KITTITAS COUNTY COMMUNITY DEVELOPMENT SERVICES

October 9, 2009

RE: Rader Short Plat (SP-09-00012)

The Kittitas County Community Development Services Department has determined that the Rader Short Plat (SP-09-00012) is a complete application and hereby grants *conditional preliminary approval* subject to the following conditions:

RADER ROAD SHORT PLAT
PART OF SECTION 17, T. 18 N., R. 19 E., W.M.
KITITAS COUNTY, WASHINGTON

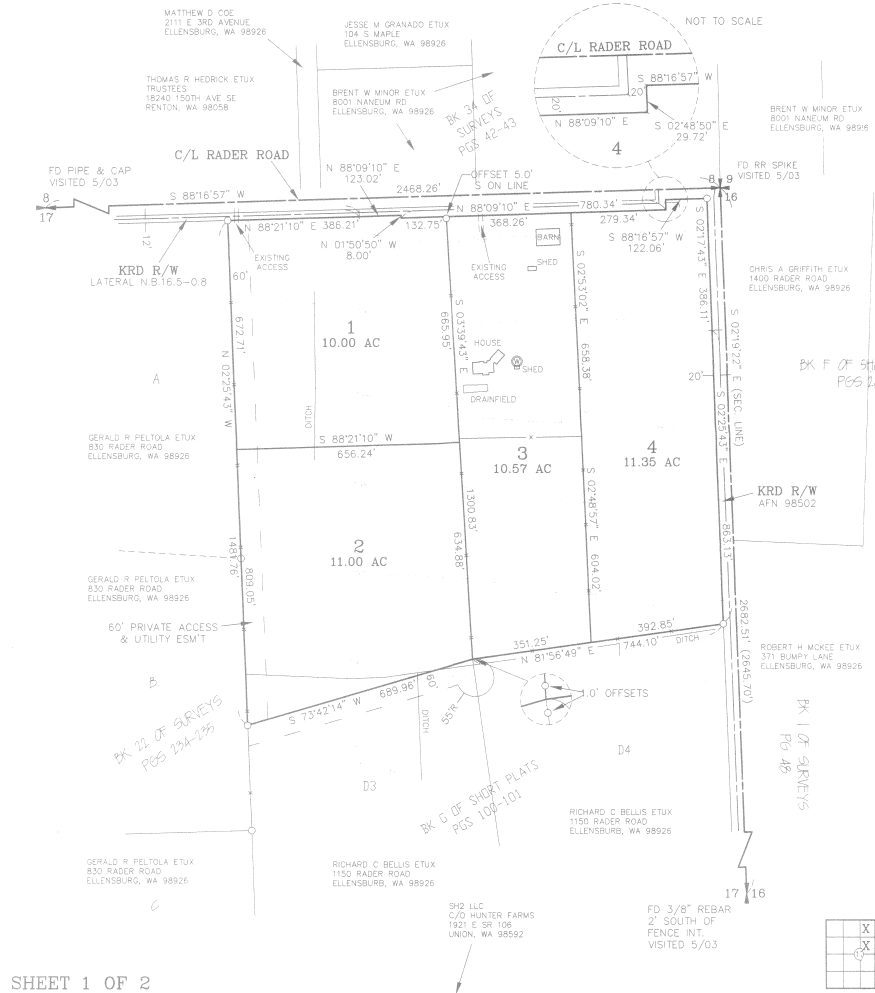
1. Both sheets of the final mylars shall reflect short plat number SP-09-00012 and an accurate legal description shall be shown on the face of the final plat.

- Lot 4 of the Rader Short Plat has a PEMC wetland across the property. The Final mylars shall reflect the location of this wetland and a statement on the plat shall read as follows: "Future development of lots may require a study by a certified wetland biologist to determine wetland classification and for buffer requirements pursuant to KCC Critical Areas Code."

11. The addresses shall be clearly visible from both directions at the County Road for all properties.
 12. The Fire Department access road shall be capable of supporting 75,000 lbs in all weather, be 20' wide, provide 13'6" vertical clearance and provide for adequate turn-around for fire department apparatus.
